From: Liz Annalls 
Sent: 18 March 2020 13:14
To: Planning.Responses <Planning.Responses@arun.gov.uk>
Subject: RE: Planning Consultation on: BR/34/20/PL

App No: BR/34/20/PL

Address: 102 Linden Road Bognor Regis PO21 2BD

Proposal: Change of use from 1 No. detached house (6 bedrooms) to 2 No. semi detached houses (1 x 5 bedroom & 1 x 3 bedroom) with a single storey rear extension.

PROPOSED CONVERSION
PROPOSED ROOF PLAN

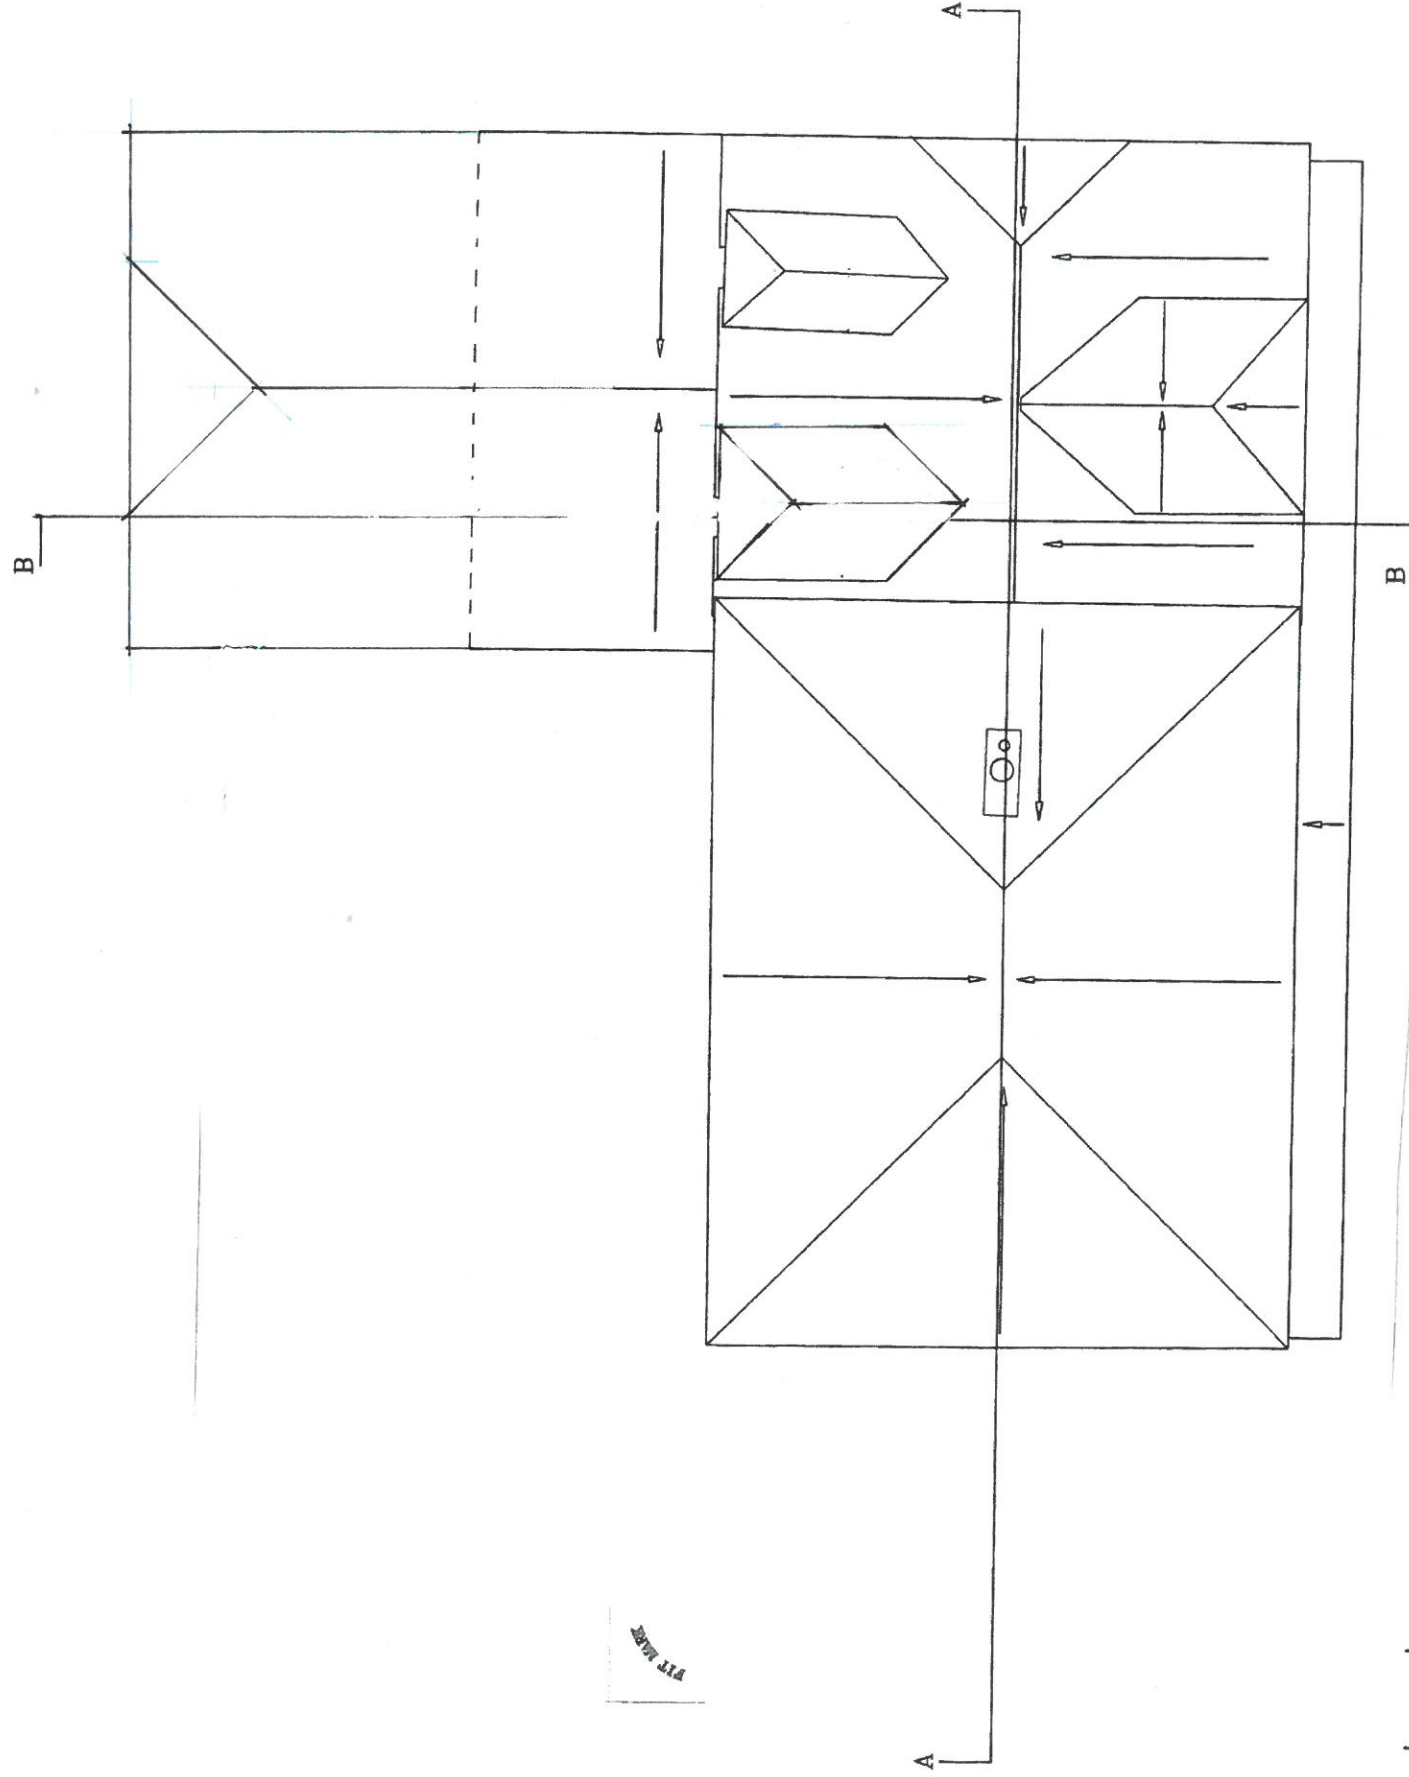
Please can confirmation be given that no works will be taking place to the roof or loft space within the property. If this is the case no further work is required, however if works to the roof area is needed, then an Initial Bat Survey would be required.

We require that a bat box is installed on the buildings onsite facing south/south westerly positioned 3-5m above ground.
